**EL PASO COUNTY PLANNING AND  
 COMMUNITY DEVELOPMENT  
 DEPARTMENT**

**GRADING AND EROSION CONTROL PLAN CHECKLIST  
 Estates at Rolling Hills Ranch Filing 2**

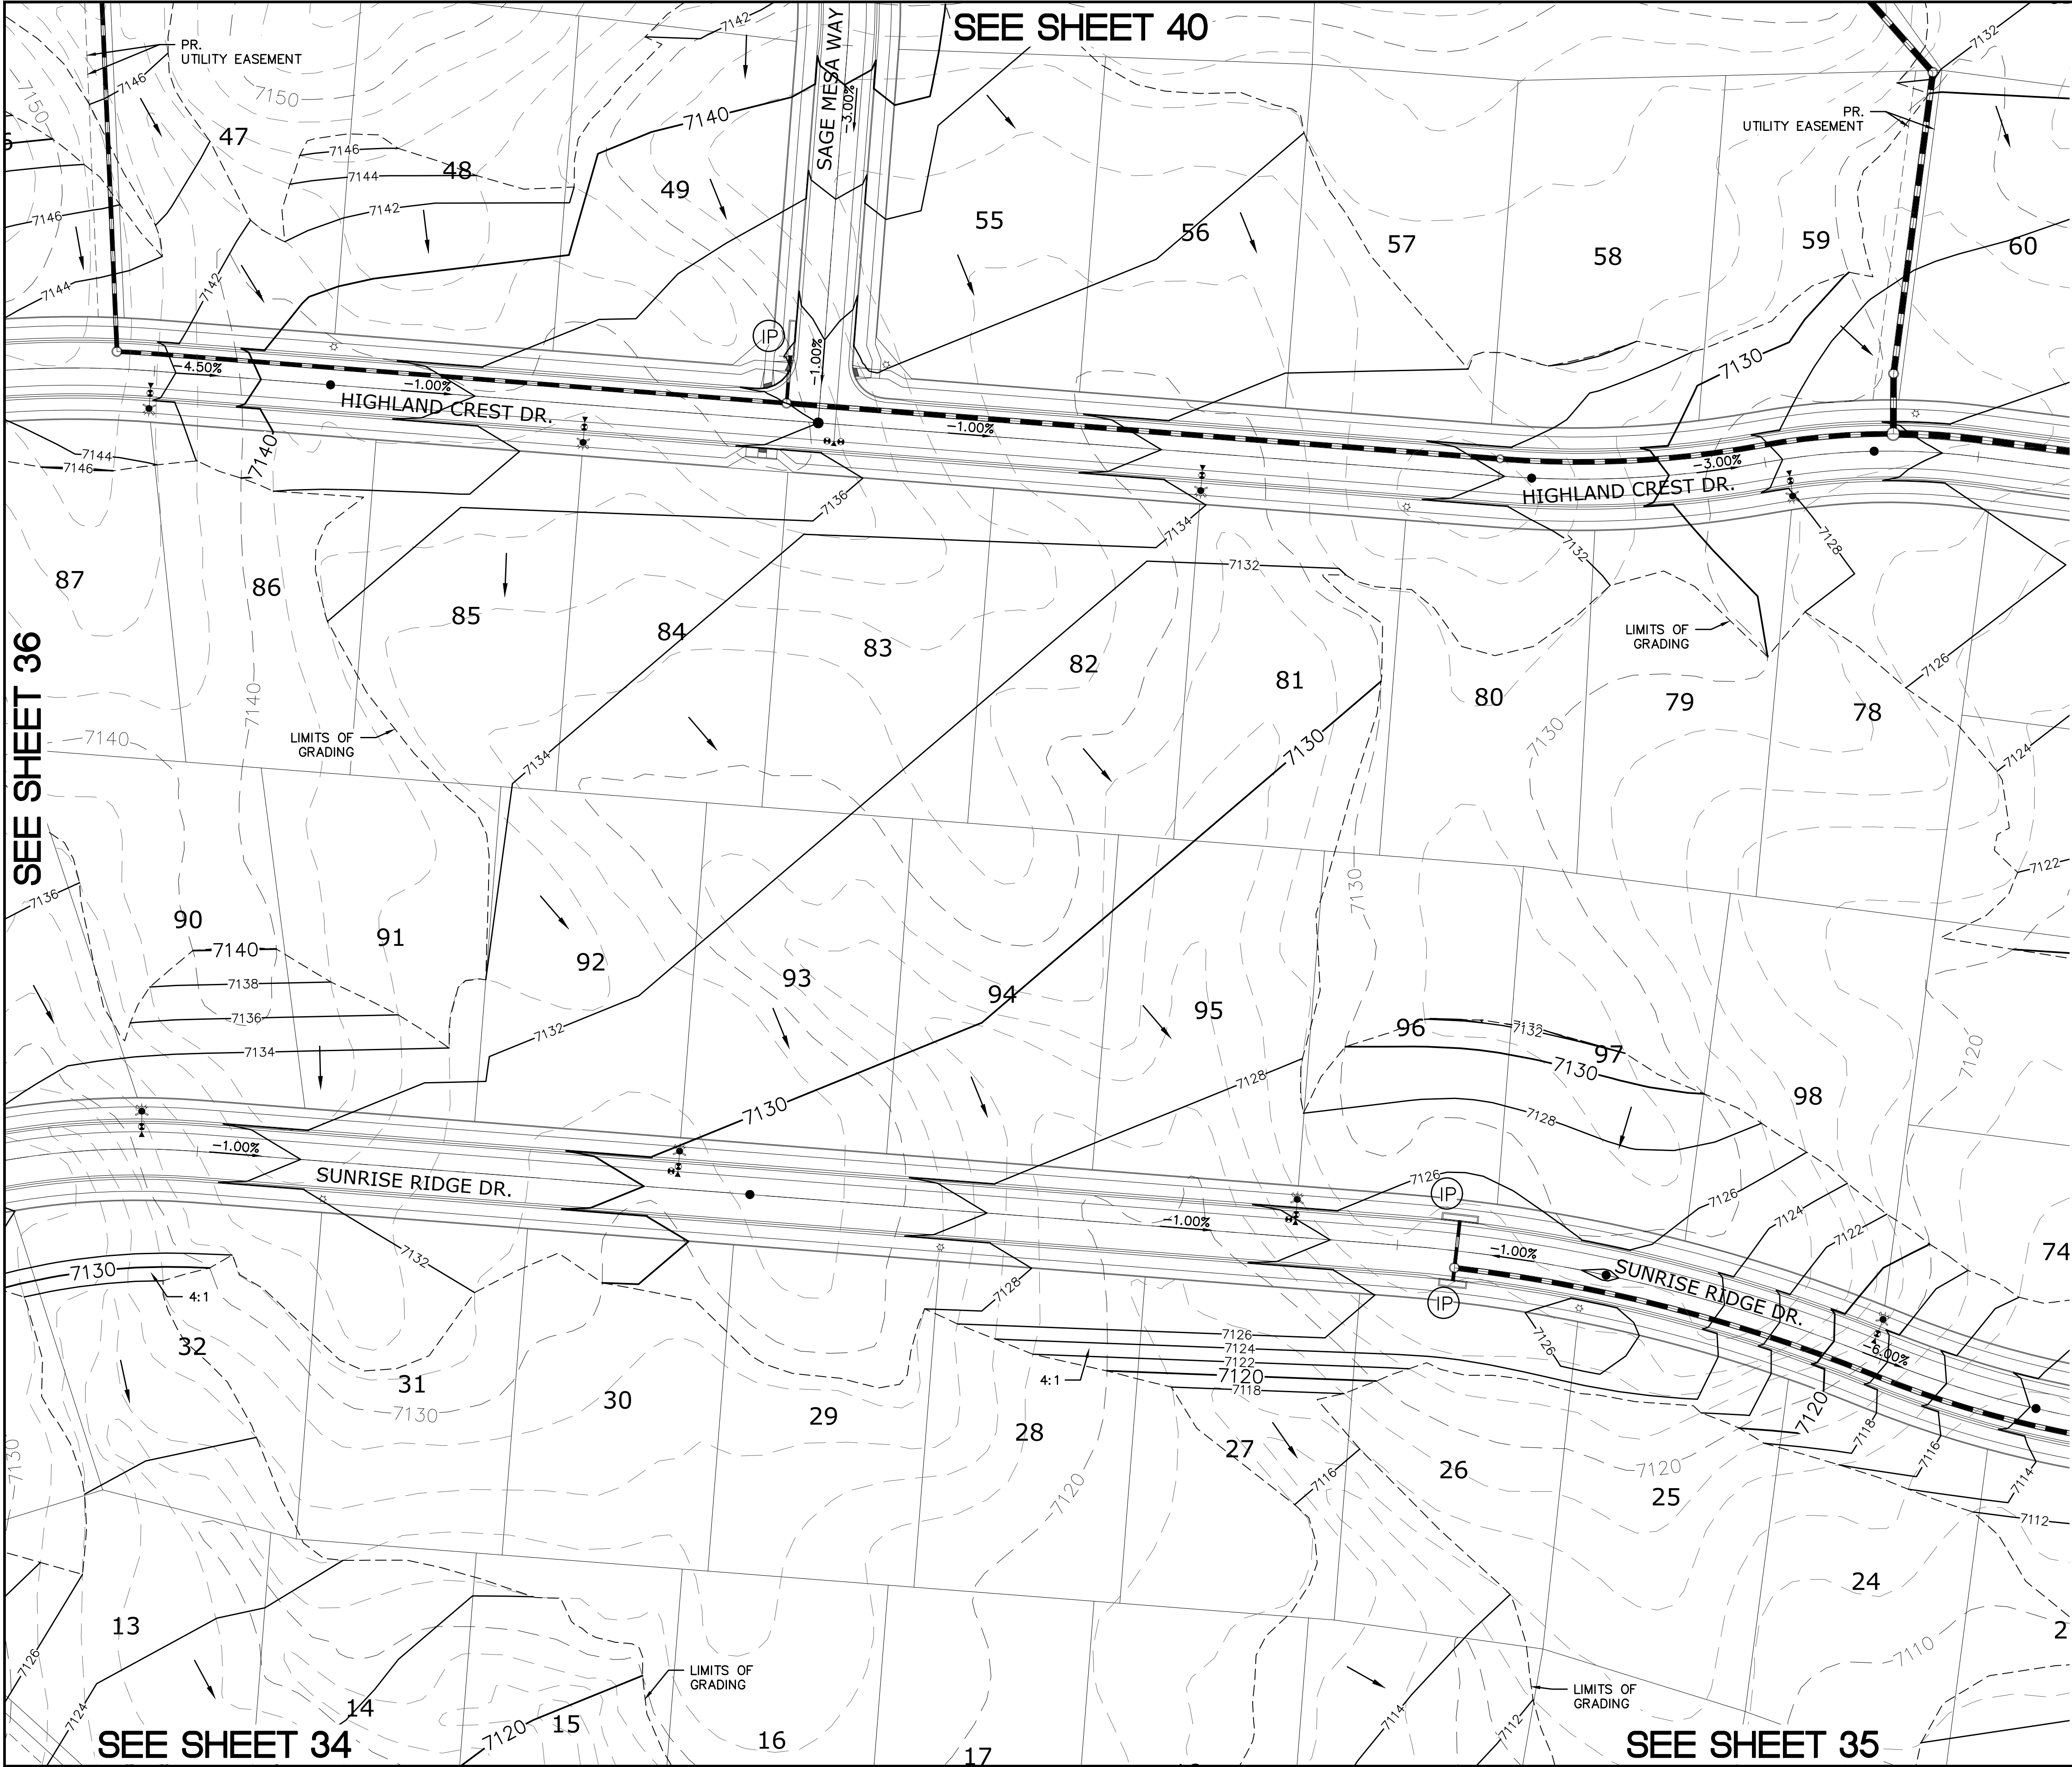
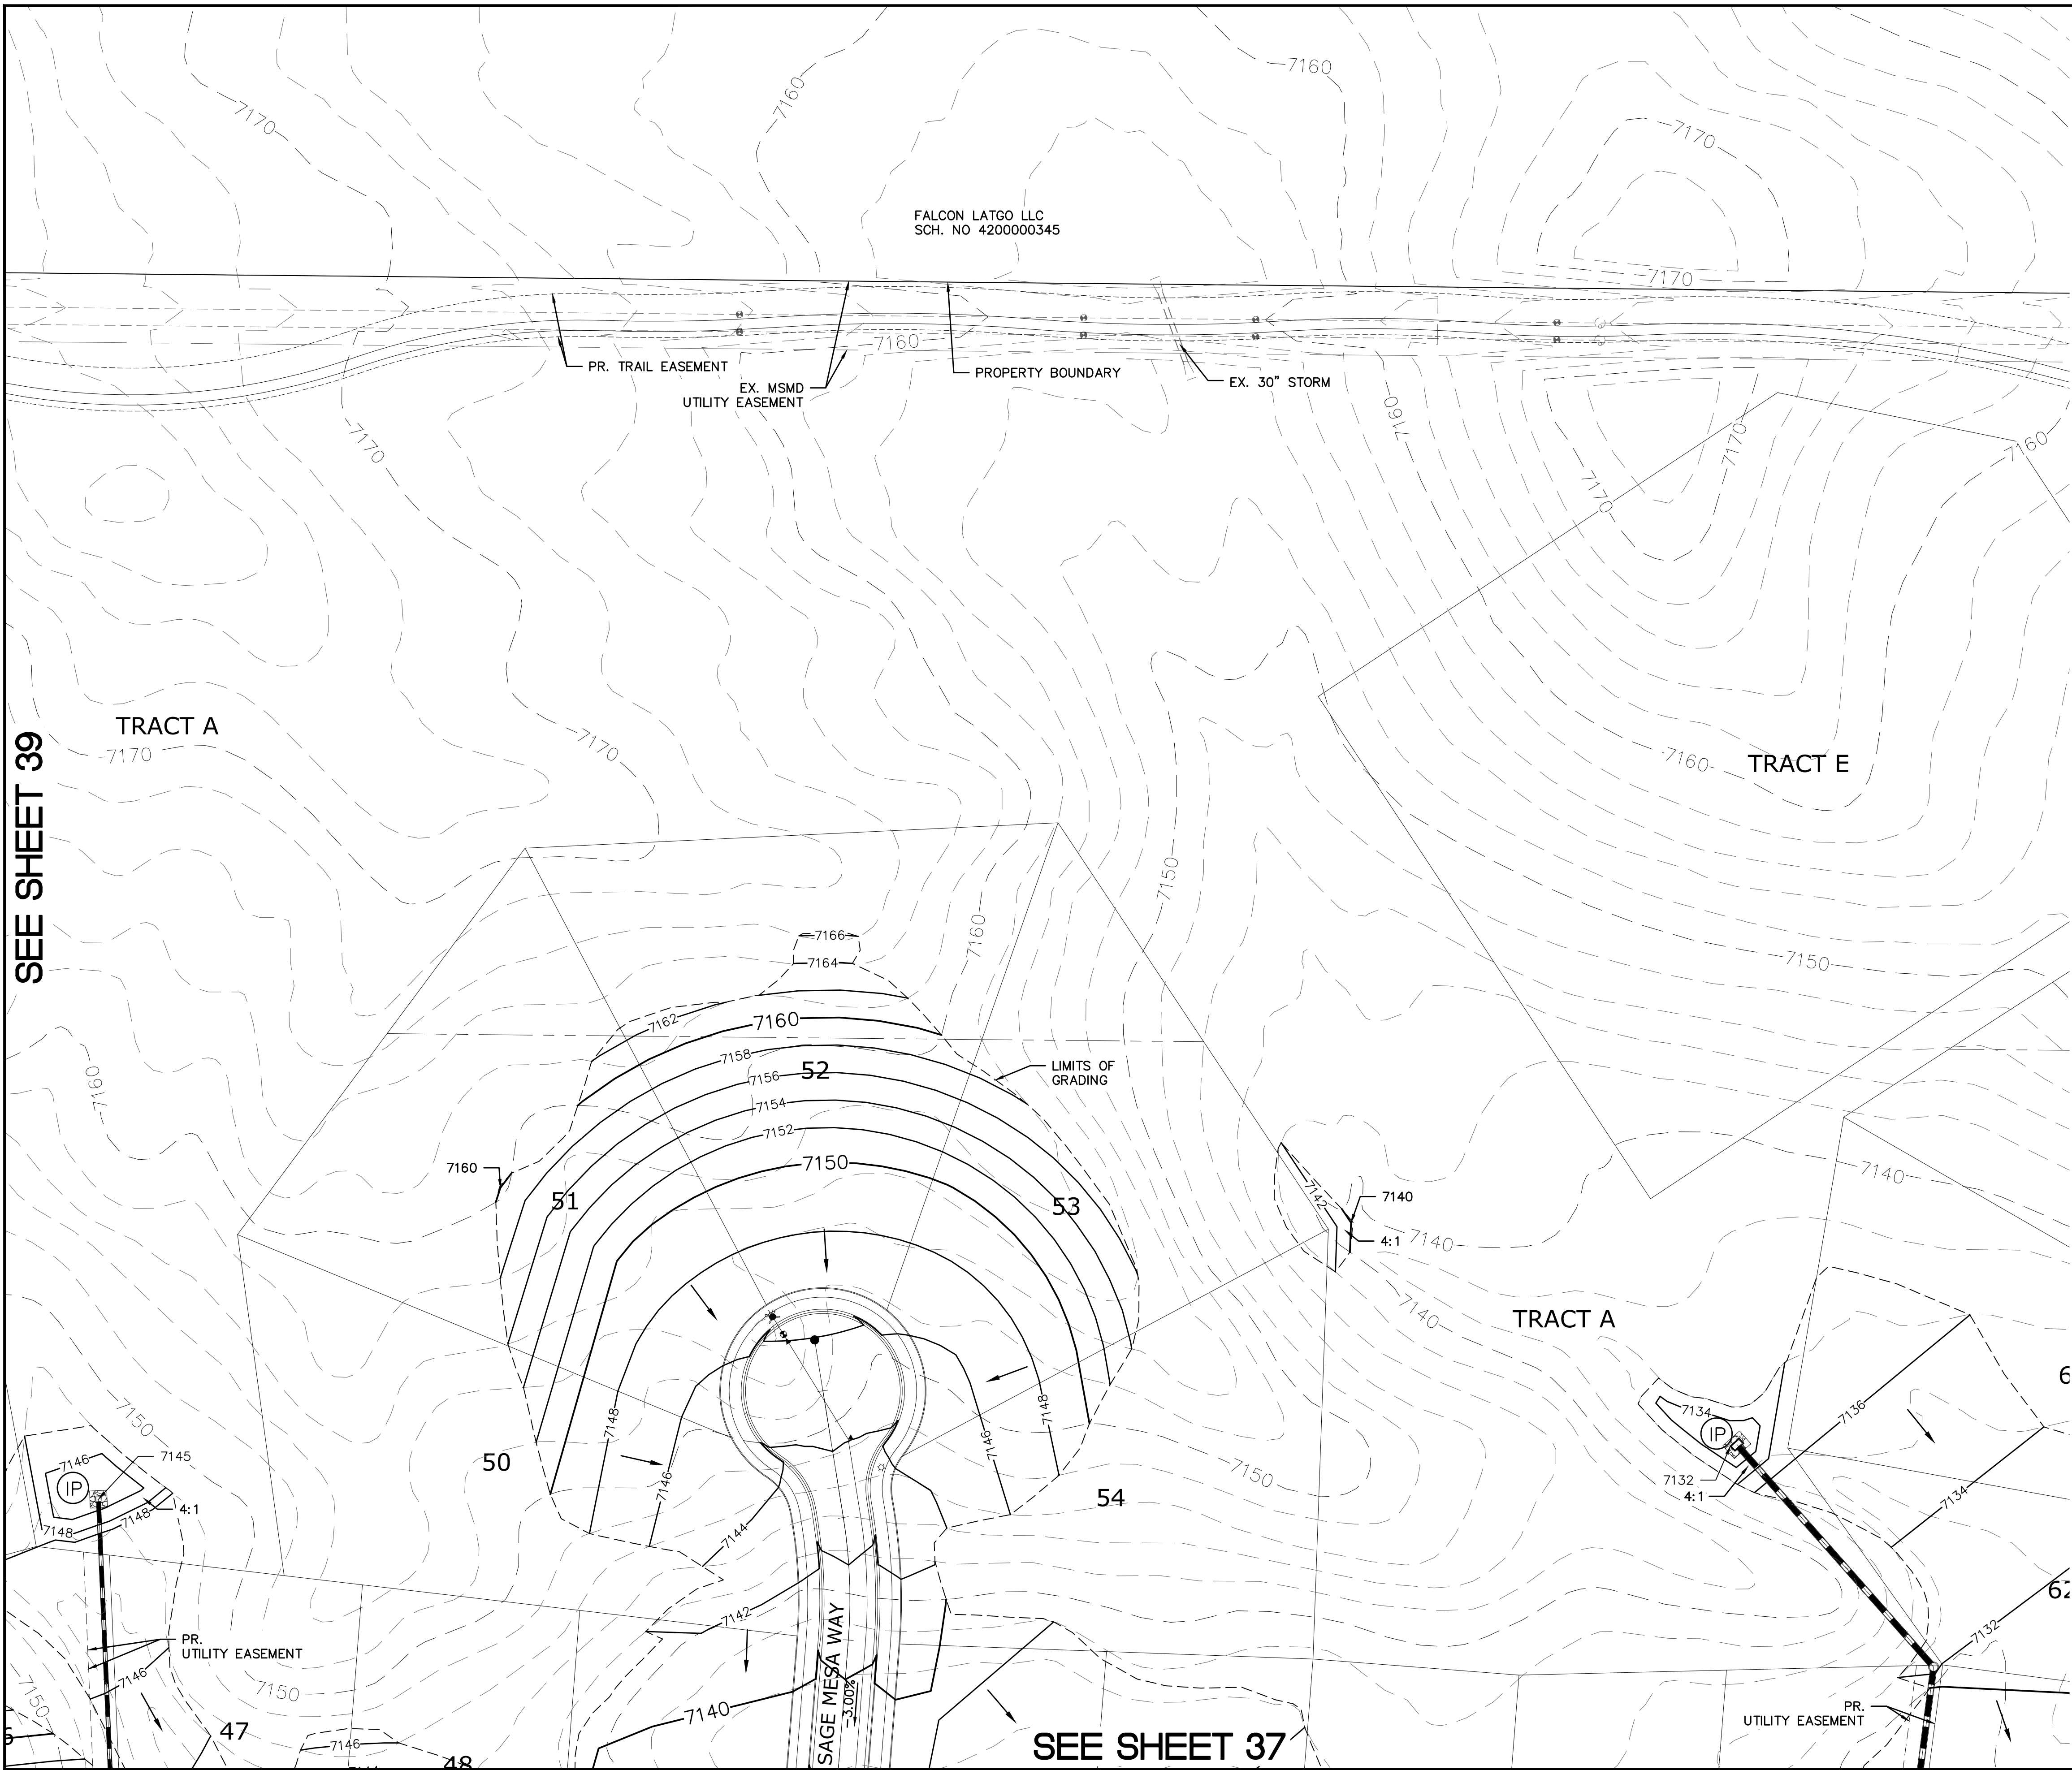
Applicant	PCD
<b>1. GRADING AND EROSION CONTROL PLAN</b>			
a	Vicinity map.	X	✓
b	Adjacent city/town/jurisdictional boundaries, subdivision names, and property parcel numbers labeled.	X	✓
c	North arrow and acceptable scale (1"=20' to 1"=100').	X	✓
d	Legend for all symbols used in the plan. Add flow direction arrows	X	X
e	Existing and proposed property lines. Proposed subdivision boundary for subdivision projects.	X	✓
f	All existing structures.	X	✓
g	All existing utilities.	X	✓
h	Construction site boundaries. See comment on GEC plans	X	X
i	Existing vegetation (notes are acceptable in cases where there is no notable vegetation, only grasses/weeds, or site has already been stripped).	X	✓
j	FEMA 100-yr floodplain.	n/a	N/A
k	Existing and proposed water courses including springs, streams, wetlands, detention ponds, stormwater quality structures, roadside ditches, irrigation ditches and other water surfaces. Show maintenance of pre-existing vegetation within 50 feet of a receiving water.	X	✓

l	Existing and proposed contours 2 feet or less (except for hillside).	X	✓
m	Limits of disturbance delineating all anticipated areas of soil disturbance. Same as Limits of Grading?	X	X
n	Identify and protect areas outside of the construction site boundary with existing fencing, construction fencing or other methods as appropriate.	n/a	N/A
o	Offsite grading clearly shown and called out.	n/a	N/A
p	Areas of cut and fill identified.	X	✓
q	Conclusions from soils/geotechnical report and geologic hazards report incorporated in grading design (slopes, embankments, materials, mitigation, etc.)	X	✓
r	Proposed slopes steeper than 3:1 with top and toe of slope delineated. Erosion control blanketing or other protective covering required.	n/a	N/A
s	Stormwater flow direction arrows.	X	✓
t	Location of any dedicated asphalt / concrete batch plants.	n/a	N/A
u	Areas used for staging, storage of building materials, soils (stockpiles) or wastes. The use of construction office trailers requires PCD permitting.	X	✓

v	All proposed temporary construction control measures, structural and non-structural. Temporary construction control measures shall be identified by phase of implementation to include "initial," "interim," and "final" or shown on separate phased maps identifying each phase.	X	X
w	Vehicle tracking provided at all construction entrances/exits. Construction fencing, barricades, and/or signage provided at access points not to be used for construction.	X	✓
x	Temporary sediment ponds provided for disturbed drainage areas greater than 1 acre.	n/a	✓
y	Dewatering operations to include locations of diversion, pump and discharge(s) as anticipated at time of design.	n/a	N/A
z	All proposed temporary construction control measure details. Custom or other jurisdiction's details used must meet or exceed EPC standards.	X	X

Sed Basins discussed as a possibility in SWMP. May be a "check" instead of "N/A" for the purposes of this checklist
